Objection to Planning Application Number 2020/62/91747/E

Location: Land adjacent to 60 Northgate, Cleckheaton, BD19 3NB

Description: Demolition of former dairy/snooker centre/storage and erection of 12 light industrial units

| Drawing:    | Plots I-F Plans and<br>Elevations      |        |                          |

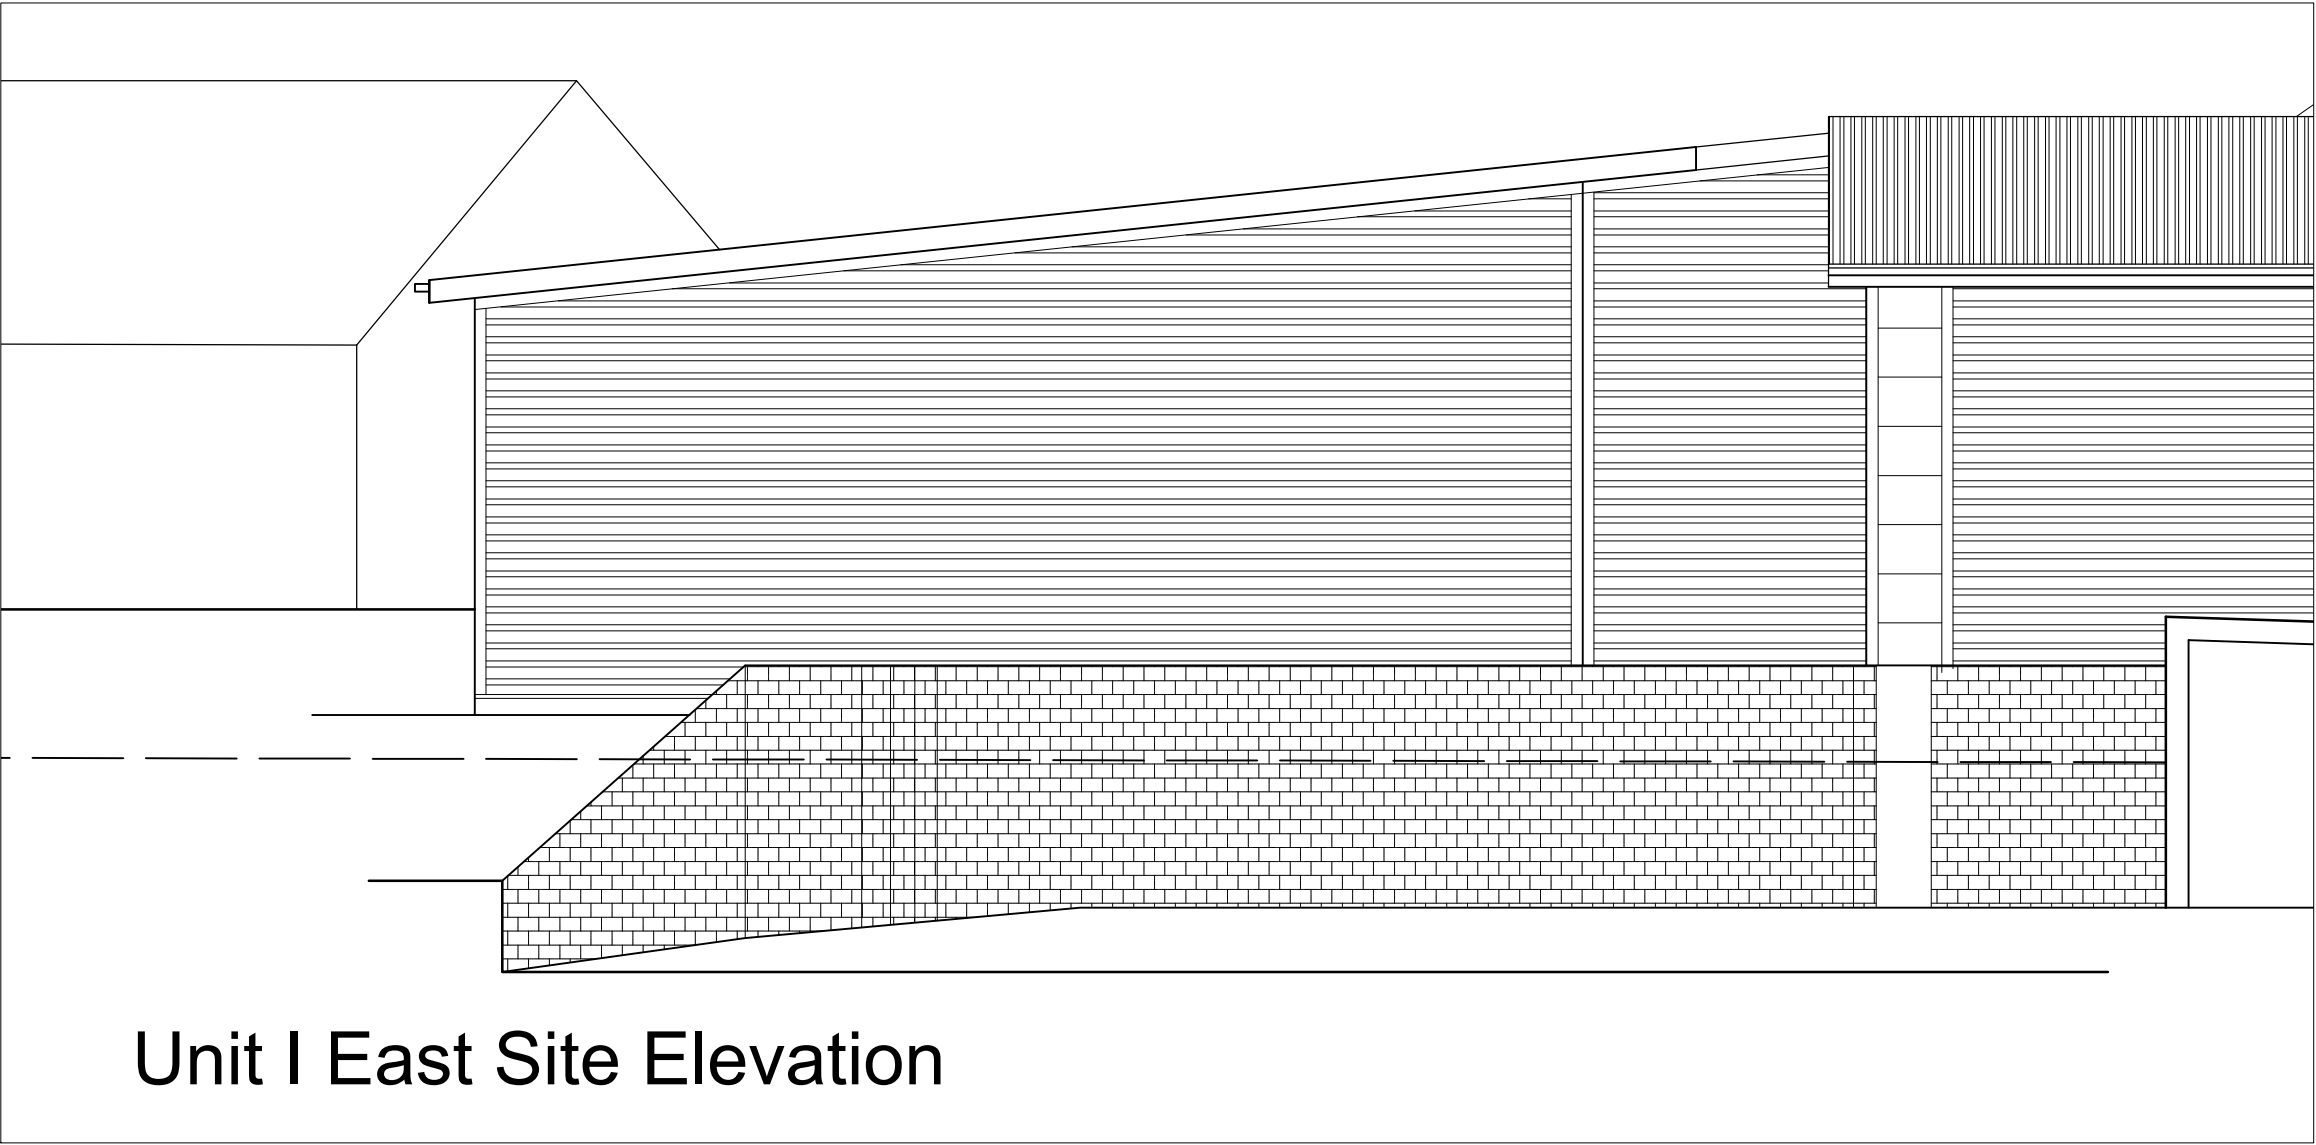
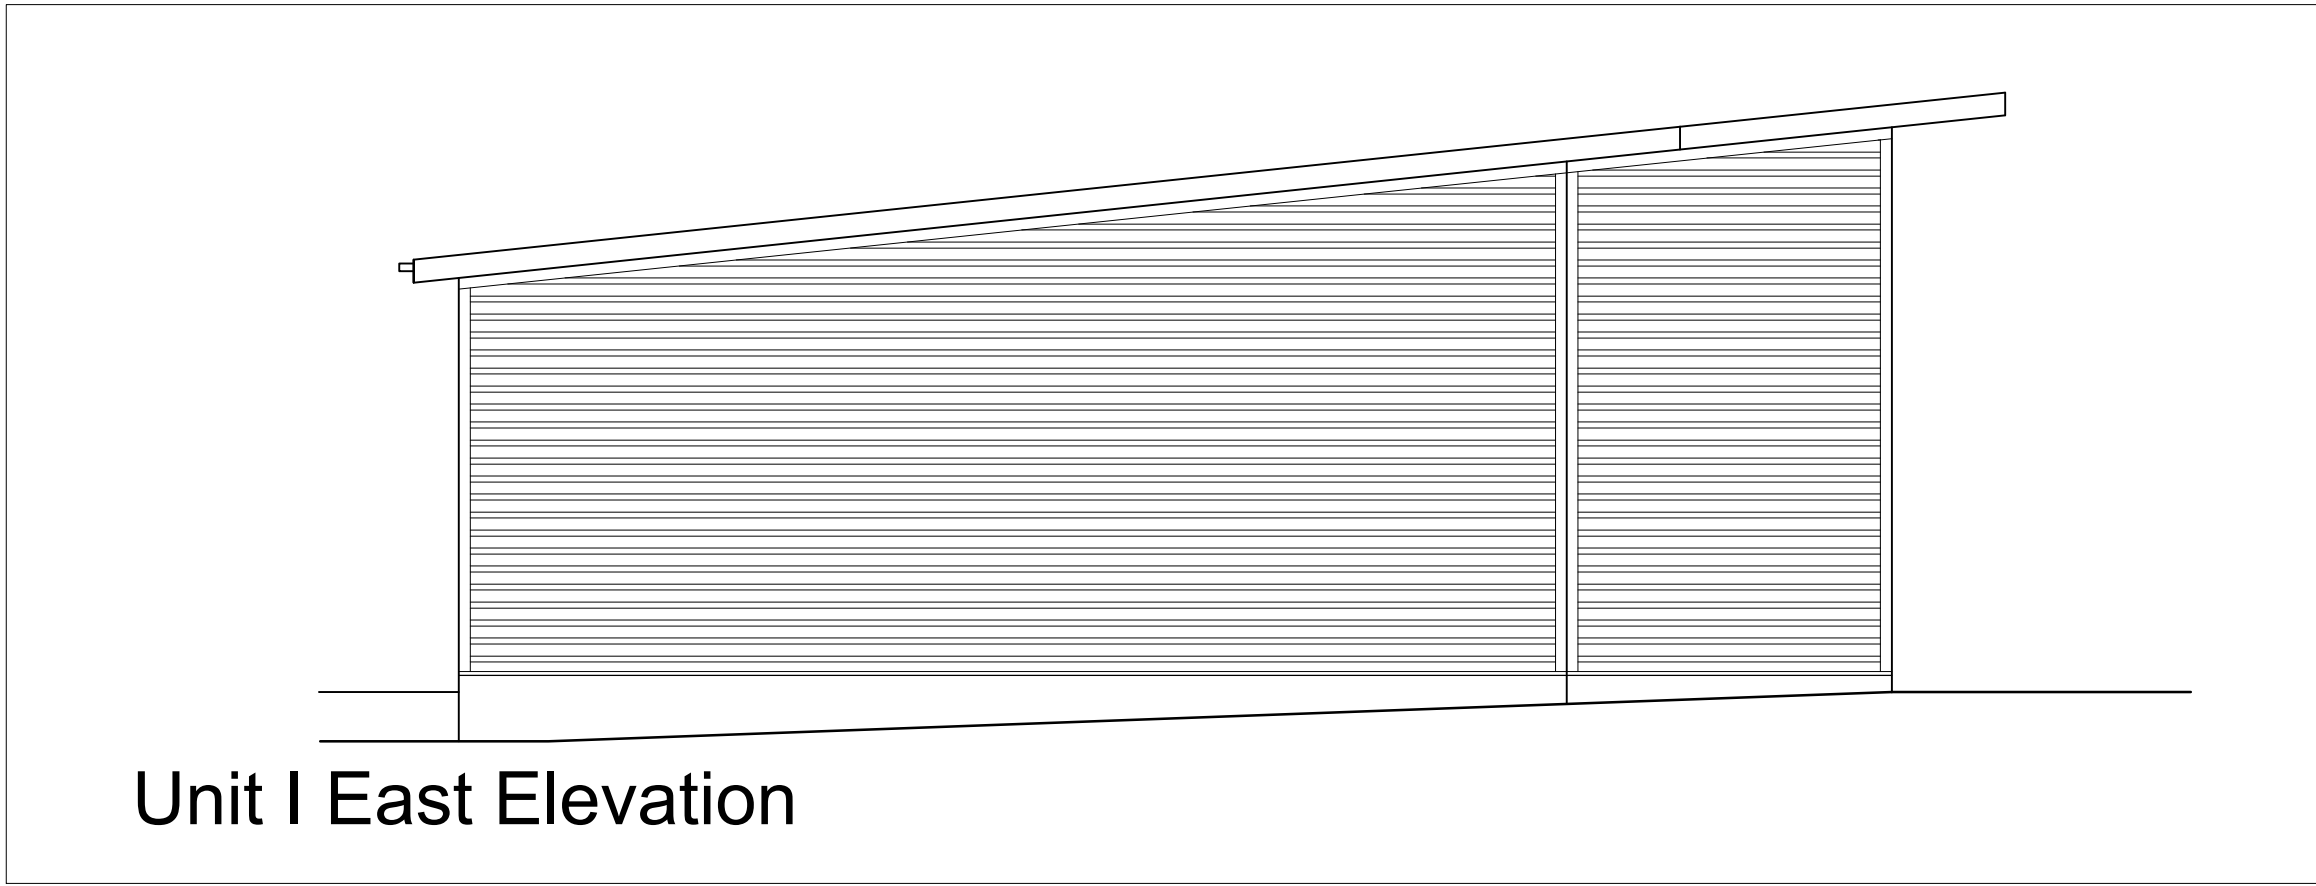
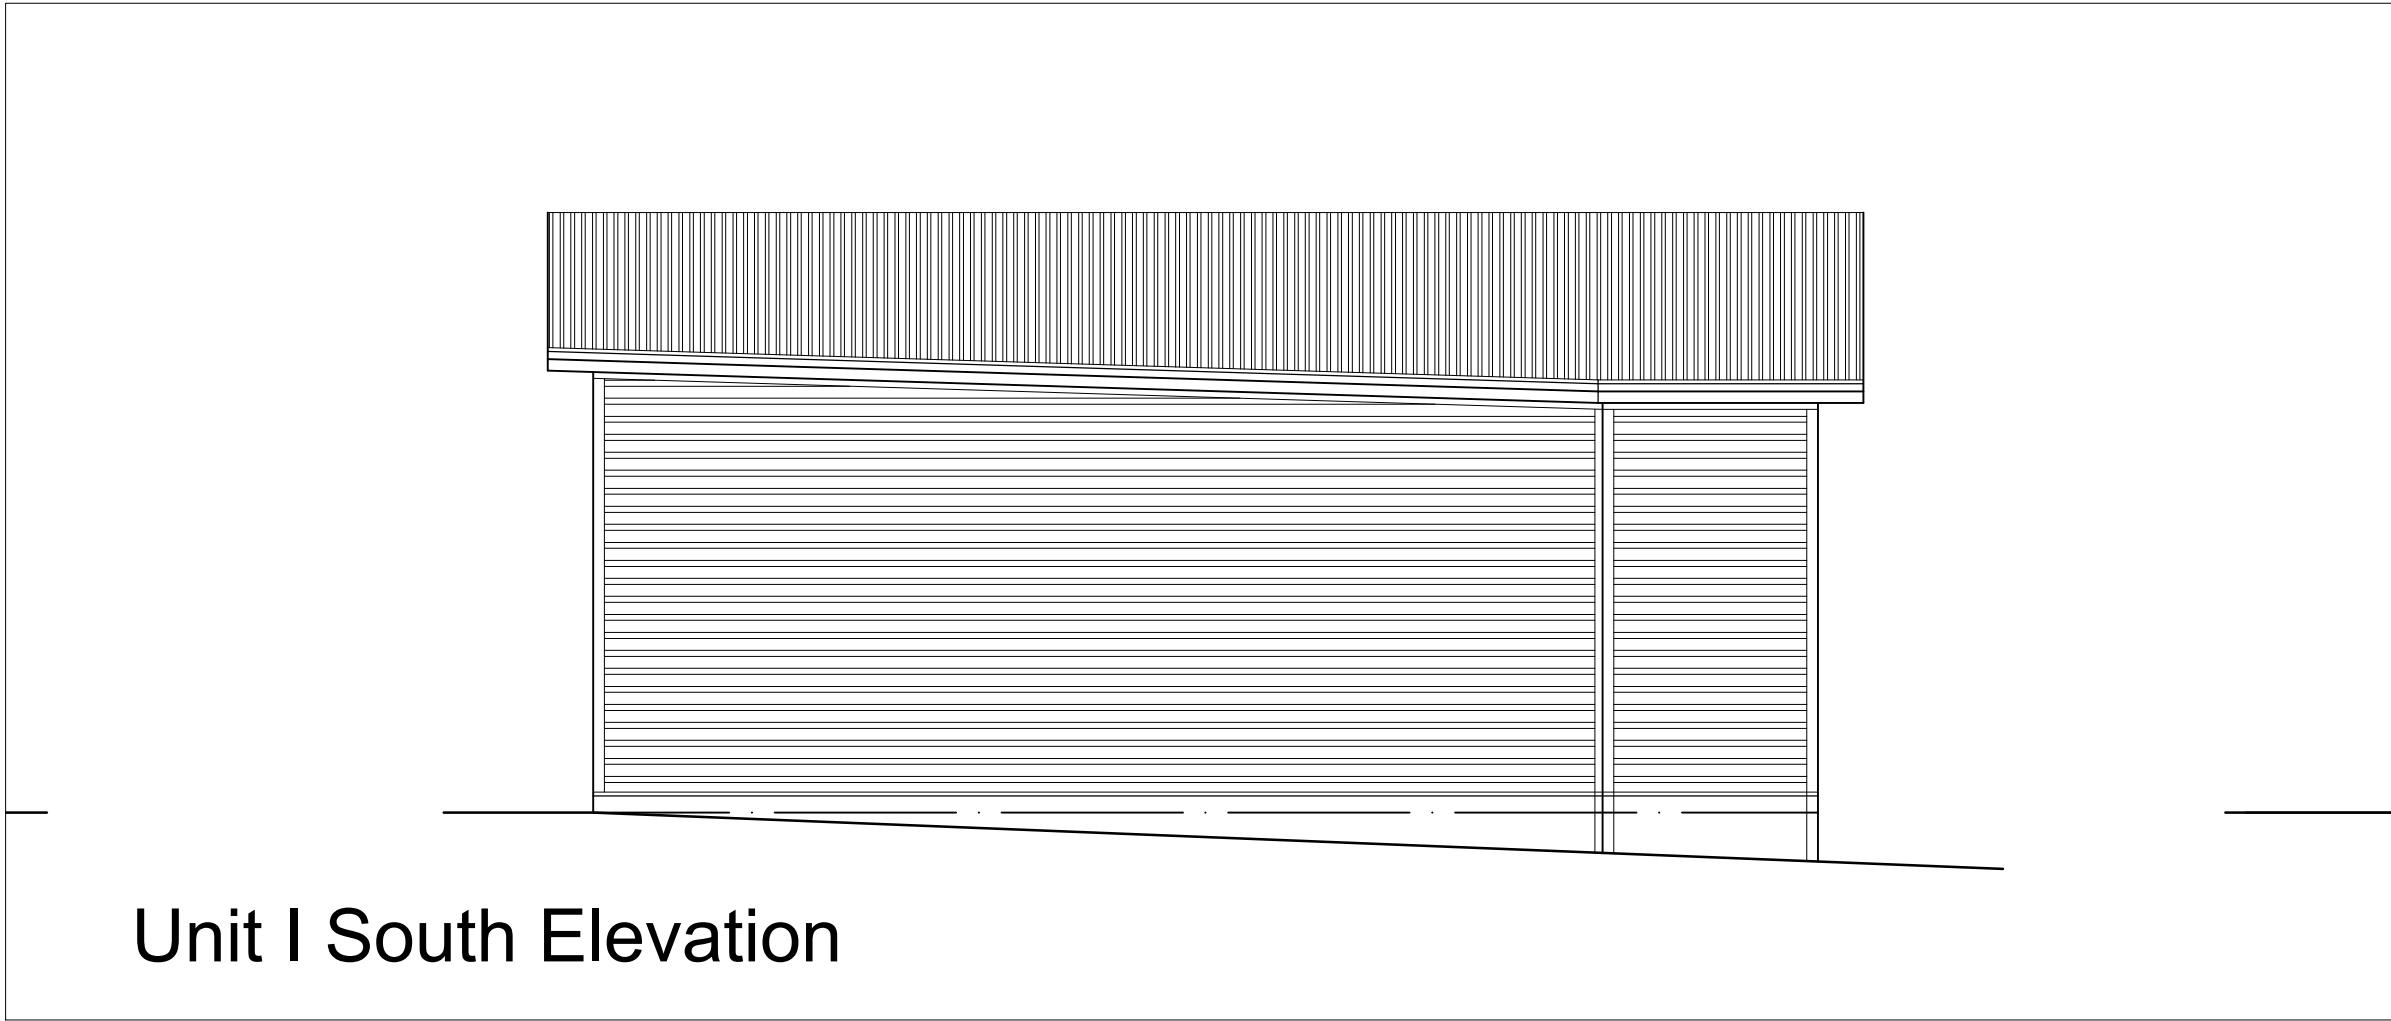
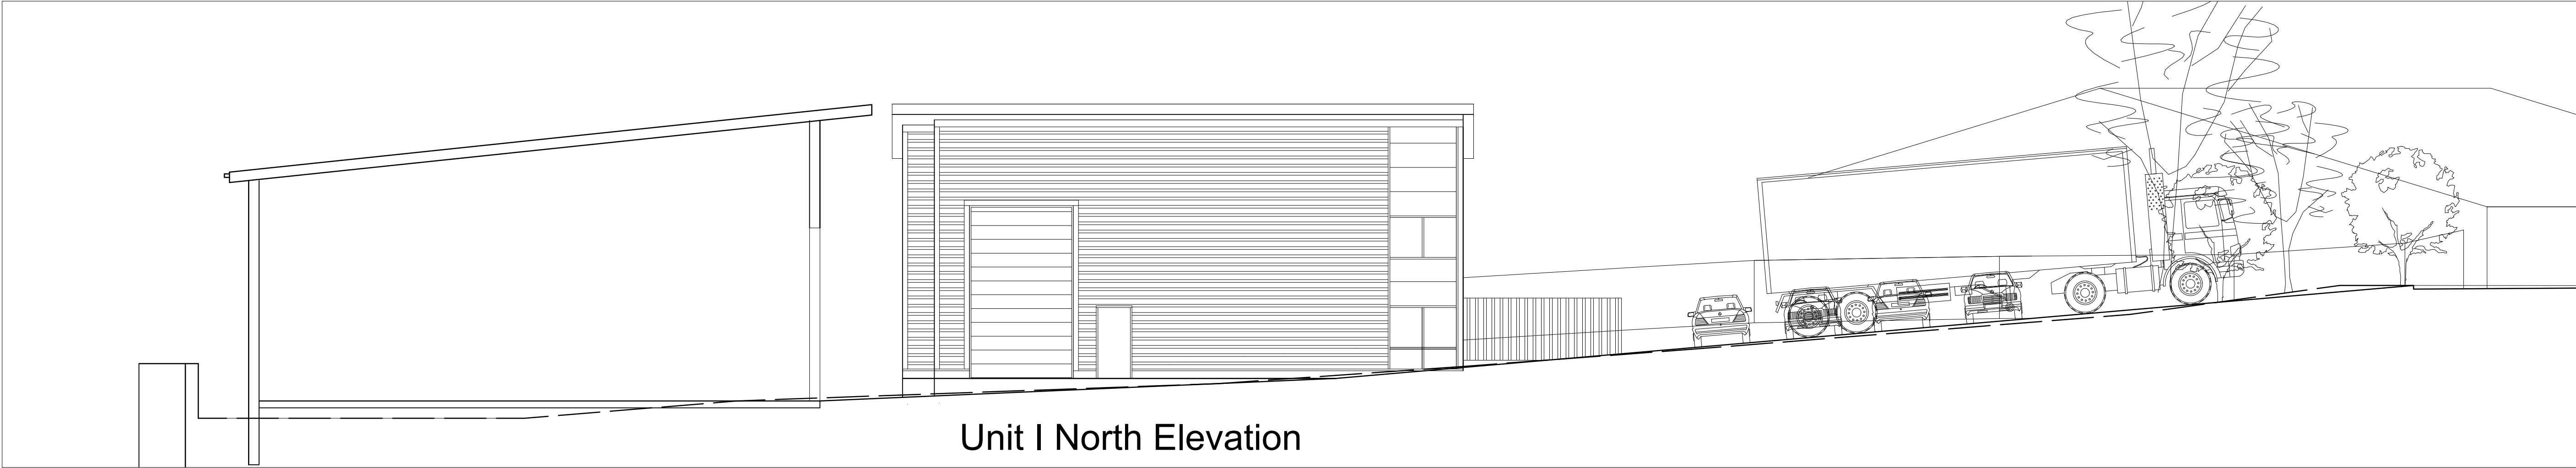
- 4.3 The Proposed Elevations show high industrial doors capable of clearing a large heavy goods wagon or articulated HGV.
- 4.4 Heavy wagons are illustrated on the Scott Lane elevation joining the junction of Northgate with Scott Lane/Whitcliffe Road residential housing, and also adjacent to the high industrial doors of Units I to L in close proximity to housing on George Street.

- 4.5 The drawings of the North Elevation Plot I to L show a multi-wheeled HGV travelling up the proposed one-way access road to exit the site onto Northgate.

- 4.6 The tall industrial doors and HGVs illustrated throughout the plans and elevations are inconsistent with light industrial use. Light industrial use should have no adverse impact on residential amenity. It is clear from the plans that the units proposed would be built for any number of industrial purposes that *would* impact adversely.

- 11.16 There is no parking provision at all within the plans for the heavy goods vehicles illustrated. The Scott Lane elevation drawing shows a HGV waiting to the front of Unit L. In the position shown it would block completely the one-way site access road and obstruct all through traffic. It is my understanding that commercial vehicle parking space is mandatory for B8 storage or distribution use. However the planning application form does not apply for consent for B8 use, which I believe is a deliberate omission.
